TfNSW reference: REN 25/00096/005

Your reference: SSD-63207219

SSD-63207219, Kingswood Battery Energy Storage System, 744 Burgmanns Lane, Kingswood 2340, Updated Traffic Impact Assessment and Amendment Report prepared by Arcadis dated October 2025.

Transport for NSW (TfNSW) is responding to SSD-63207219, the Kingswood Battery Energy Storage System request, referred via the Major Projects Portal.

Figure 2 – New England Highway / Whitehouse Lane upgrade

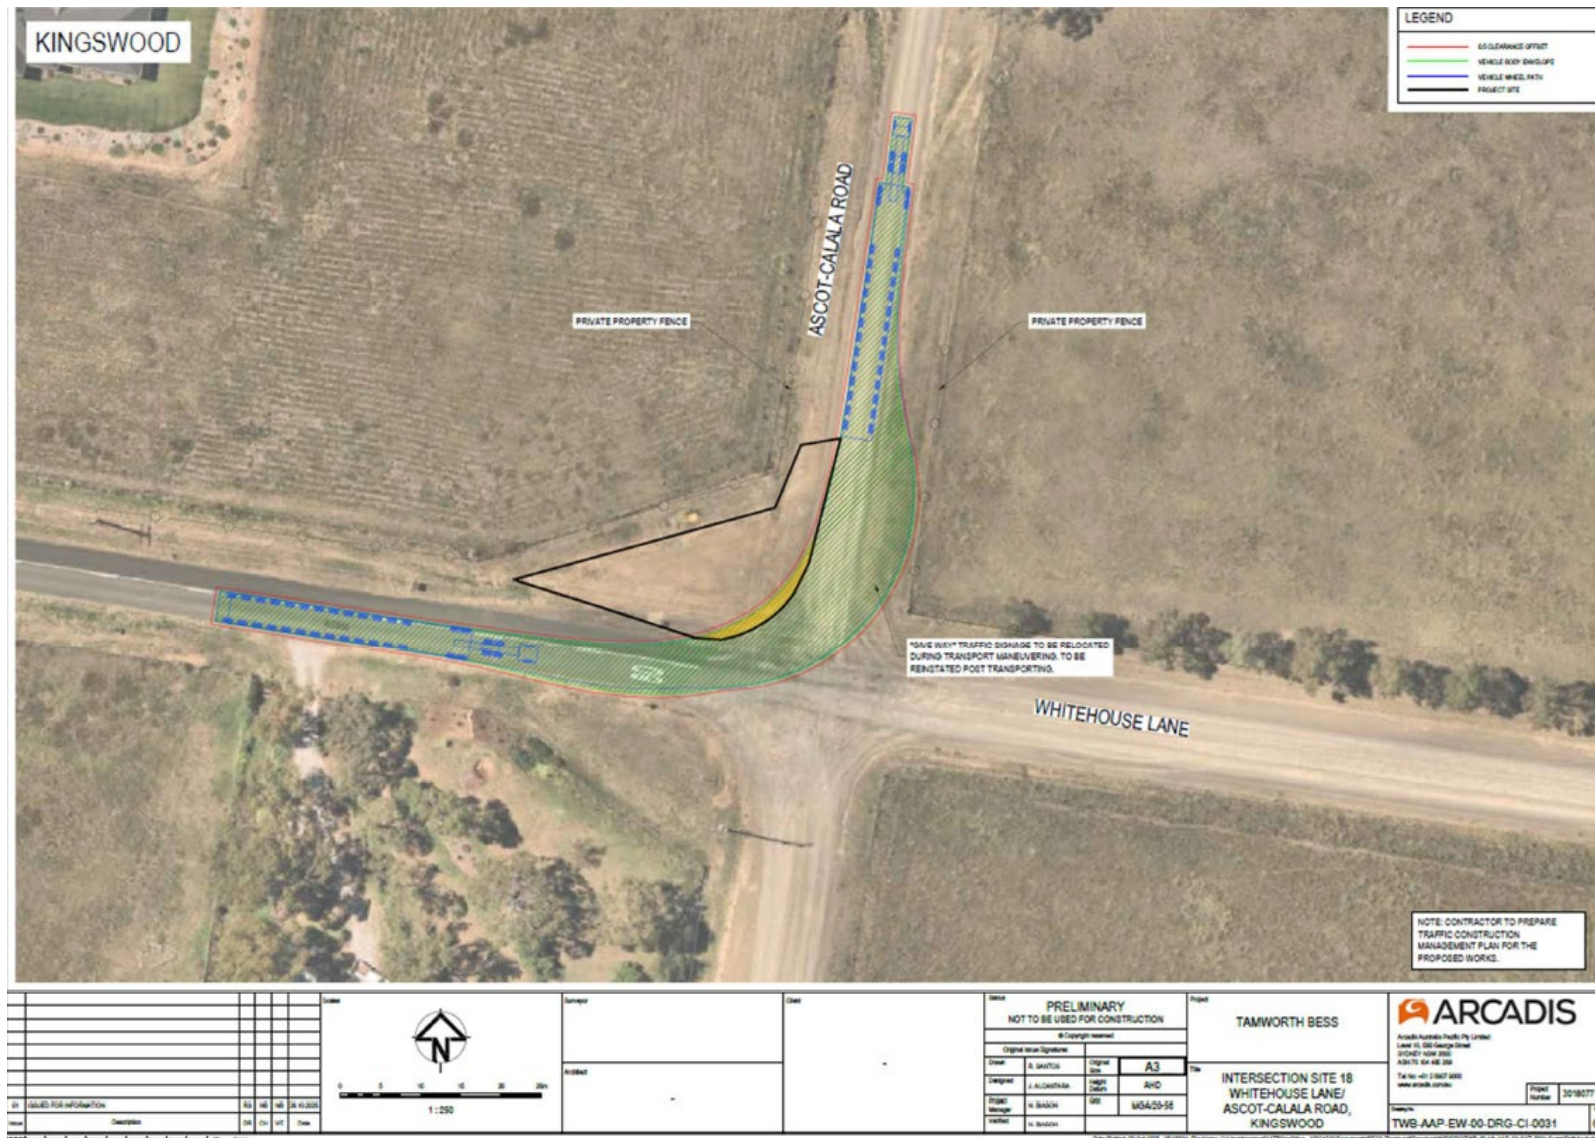
1. Incorporate a notation on the plans at the intersection of Whitehouse Lane/New England Highway which highlights the need to address the structural capacity of shoulder pavement and upgrade to suitable shoulder material if required.

2. Incorporate a notation on the plans at the intersection of Whitehouse Lane/New England Highway which highlights shoulder widening to be provided to reinstate the width used to facilitate the now south bound lane edge line.

3. Heavy vehicle access restriction: TfNSW previously requested a swept path analysis of the New England Highway/Burgmanns Lane intersection under Point 1(d) of its EIS response. The revised TIA justifies omission of this analysis on the basis that this intersection will be used only by light vehicles. TfNSW requires a condition and enforceable traffic management measures within the Construction Traffic Management Plan (CTMP) to ensure that heavy vehicle construction traffic is prohibited from using this intersection, with appropriate monitoring and enforcement provisions.
